# TRAFFIC IMPACT STUDY

**Schmidt Property**  
**El Paso County, Colorado**  
PCD File No. P-22-022

September 2022  
Revised:  
January 2023

**SM ROCHA, LLC**  
TRAFFIC AND TRANSPORTATION CONSULTANTS

Figure 2
CONCEPTUAL SITE PLAN
September 2022
Page 4

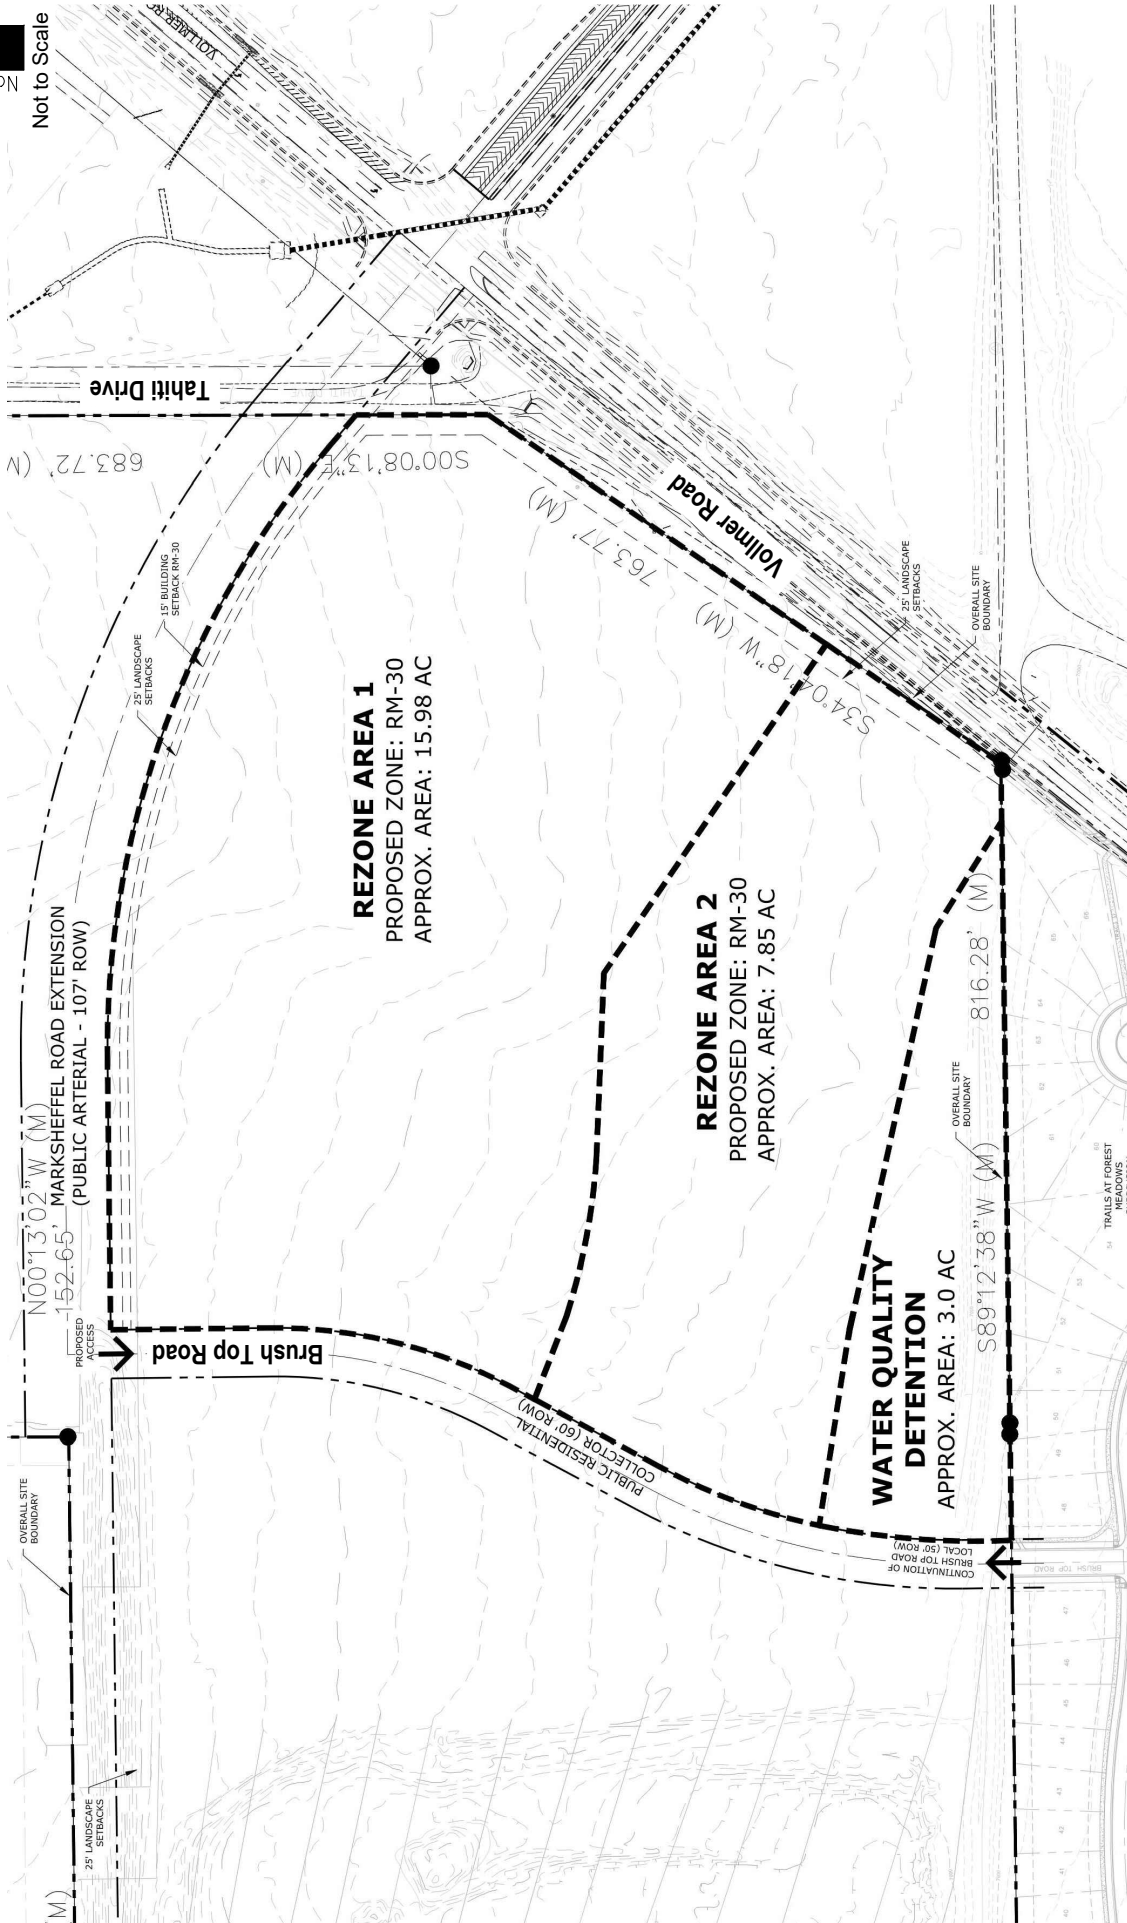
Based on intersection spacing requirements, full movement access at this location will not be approved. Any proposed deviations for limited access would need to be discussed prior to submittal.

In review of Section 2.4, Tables 2-33 through 2-36 of the County's ECM, Vollmer would require minimum 900ft spacing from Marksheffel. In review of the latest plan, it appears the proposed full-movement access meets the minimum requirement, or may be short by only a few feet. As such, full-movement conditions is believed to be appropriate at this location, the southernmost edge of the property.

Access spacing or any need for standards deviation request can be assessed further with future preliminary plans, if applicable.

Figure 4
BACKGROUND TRAFFIC - YEAR 2027
 Volumes & Intersection Geometry
 AM / PM Peak Hour
 (ADT) : Average Daily Traffic

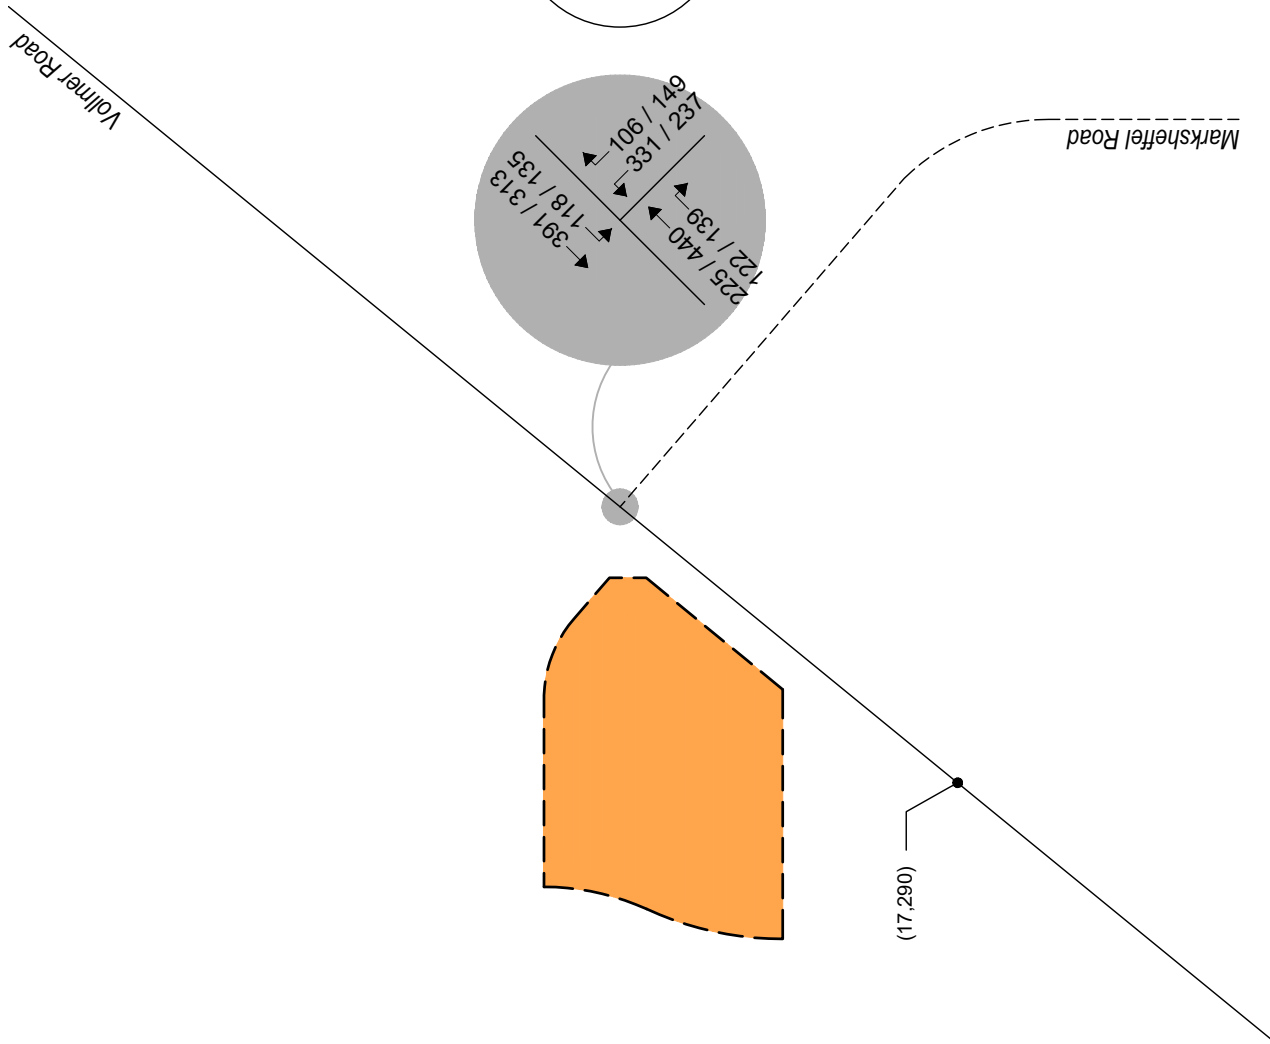
Include discussion on where Business Drive came from and what its configuration is, as it's shown under future conditions analysis - Background traffic

Discussion added in this paragraph.
